**Re: Amreston Homes, LLC at Calle Cuarta Lots 1-21
Erosion and Sediment Control Plan
Engineer's Stamp Date: Missing – G14E097_AMR - (SWQ-2026-00018)**

Based on the information in your submittal received on 3/3/26, the ESC Plan and NOI cannot be approved until the following comments are addressed.

<p>ESC-1</p>
--	--------------

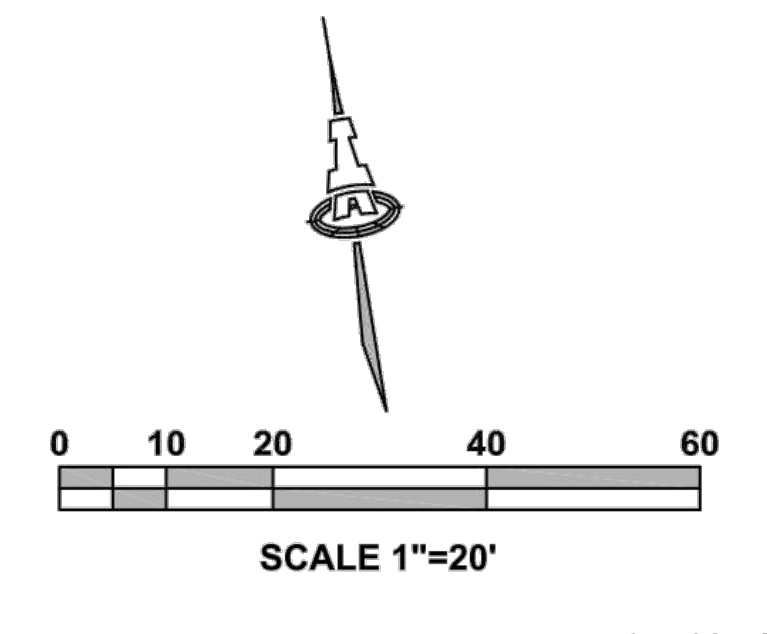
1. Amreston Construction, LLC submitted its NOI with ID# NMR1007RY, which appears to be the contractor's coverage. The City and the EPA require the property owner's NOI, currently active as NMR100632, for Yes Calle Cuarta TH, LLC. County records show that Yes Calle Cuarta TH, LLC still owns all of the lots. Please make sure that the name on Amreston's NOI matches the spelling on its deed when purchasing the lots.
2. The ESC Plan isn't stamped and signed by a professional. All sheets must be certified by either an NMPE or a CPESC. The date on the certification must be updated on all sheets if any one sheet is changed.
3. These lots are designed to drain stormwater through weep holes in the backyard walls. A silt fence is required in the rear yards inside the walls on all the lots, in addition to the silt fence shown in the side yards at the ends of the lots.
